Roads and Maritime Reference: SYD15/01051/07 (A18449511)
DP&E Reference: SSD 7155 MOD 2

**SECTION 96 MODIFICATION TO APPROVED WAREHOUSE AND DISTRIBUTION CENTRE –
5-35 YARRUNGA ROAD, PRESTONS**

Roads and Maritime has reviewed the additional information and provides the following comments for consideration in the determination of this application:

**SWEPT PATH ANALYSIS
OF A 25m ARTICULATED
VEHICLE TURNING RIGHT FROM
BERNERA INTO YARRUNGA
AND A 19m ARTICULATED
TURNING LEFT FROM
YARRUNGA INTO BERNERA**

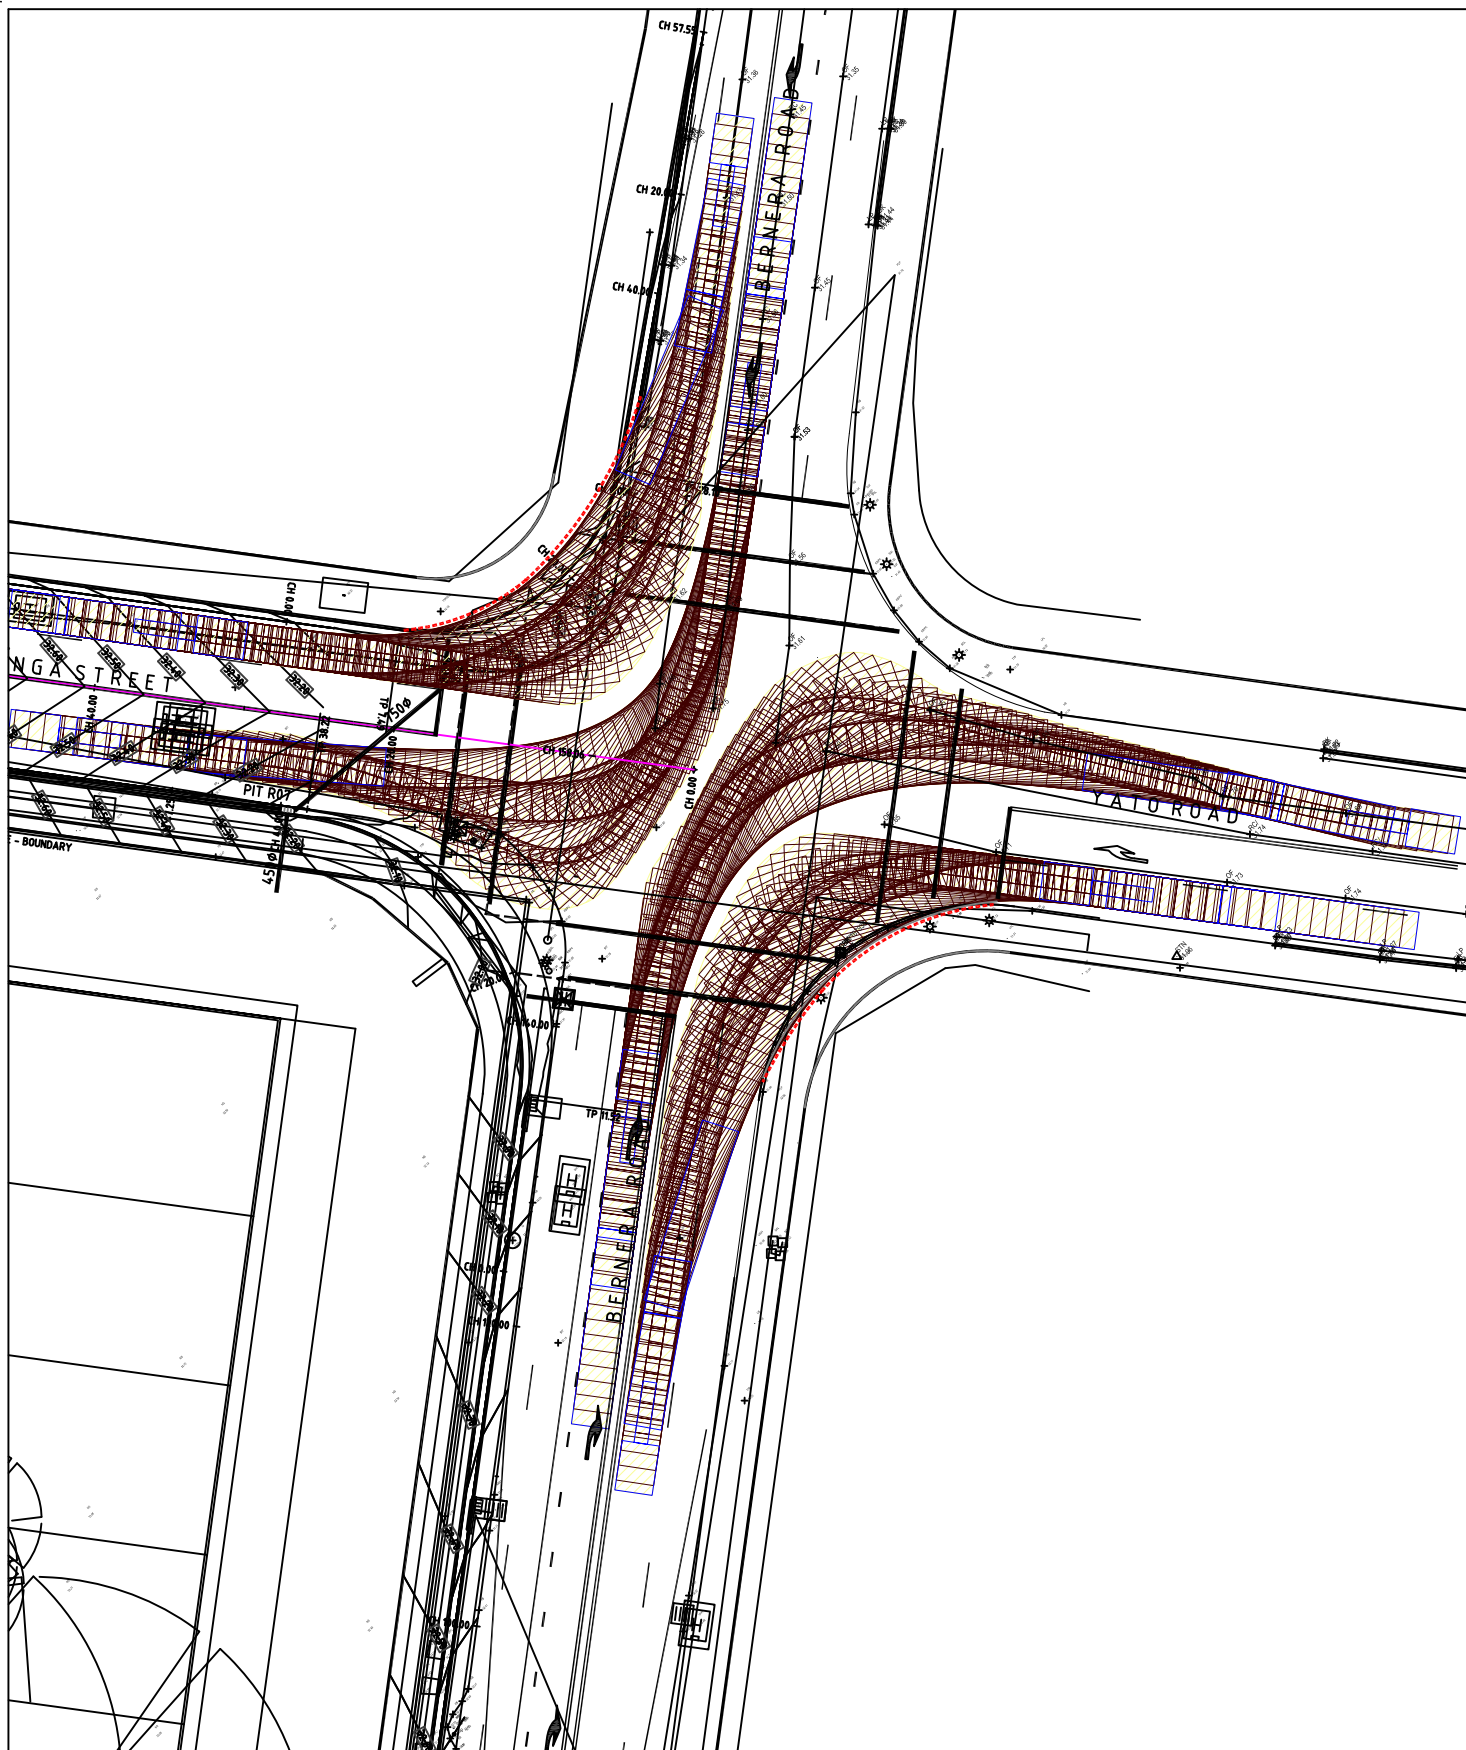
It is noted that the proposed intersection design by the proponent does not allow for complimentary left turns that will be undertaken by 26m B-doubles as part of a dedicated right turn/diamond phase at this intersection (Roadworks Swept Paths Plan Issue E dated 6 April 2017 and Roadworks Layout Plan Issue E dated 19 January 2017).
